From: mattnaish mattnaish [REDACTED]
Sent: 13 April 2017 16:40
To: David Easton
Subject: Re: LU/70/17/CLP - 32 Maxwell Road
Importance: High

I have been examining the above certificate of lawfulness and believe that the proposed development accords with the limitations of Schedule 2, Part 1, Class B of the Town and Country (General Permitted Development) Order 2015 (as amended).

DRWG: DS/SHIELDS/02  
 DATE: 16/02/2017  
 DRWN: DEADSPACE DESIGNS

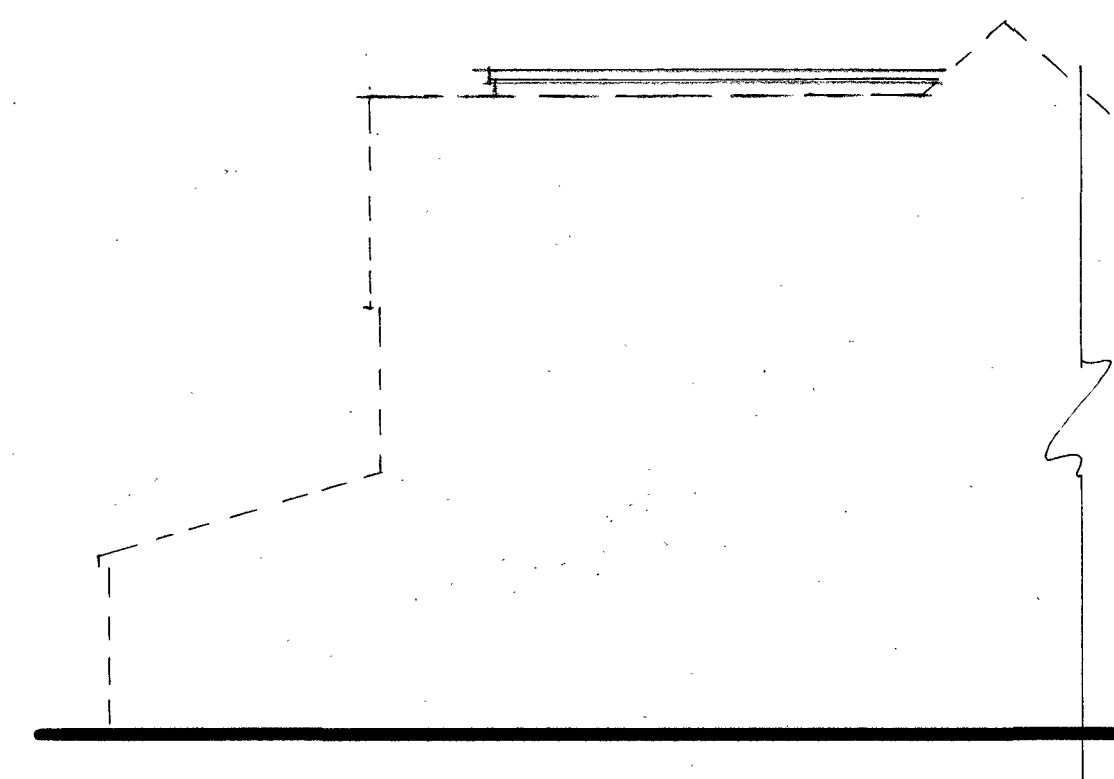
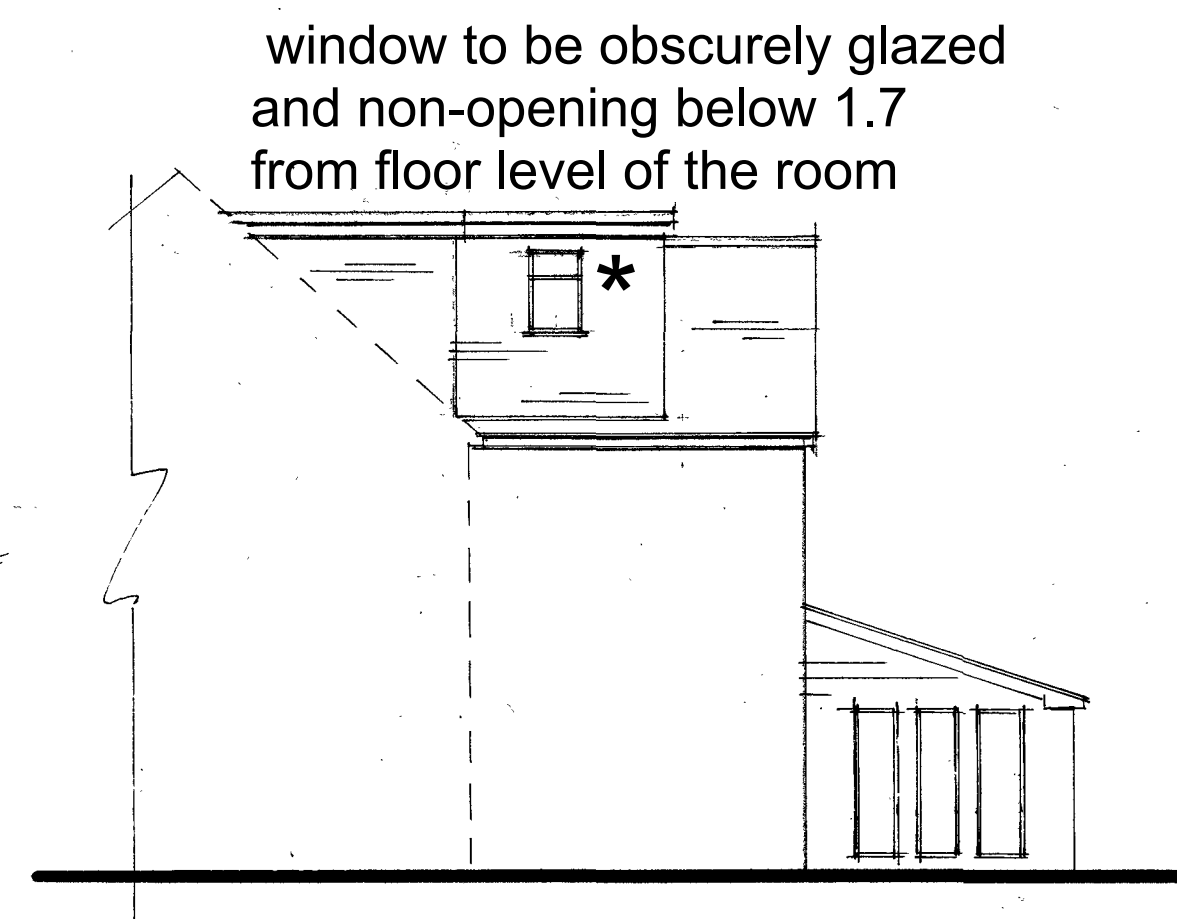
However, I would be grateful if you could please provide confirmation that the window situated in the southern elevation of the proposed dormer will be obscurely glazed and non-opening below 1.7 from floor level of the room in which the window is installed.

I have attached an amended plan with the note added
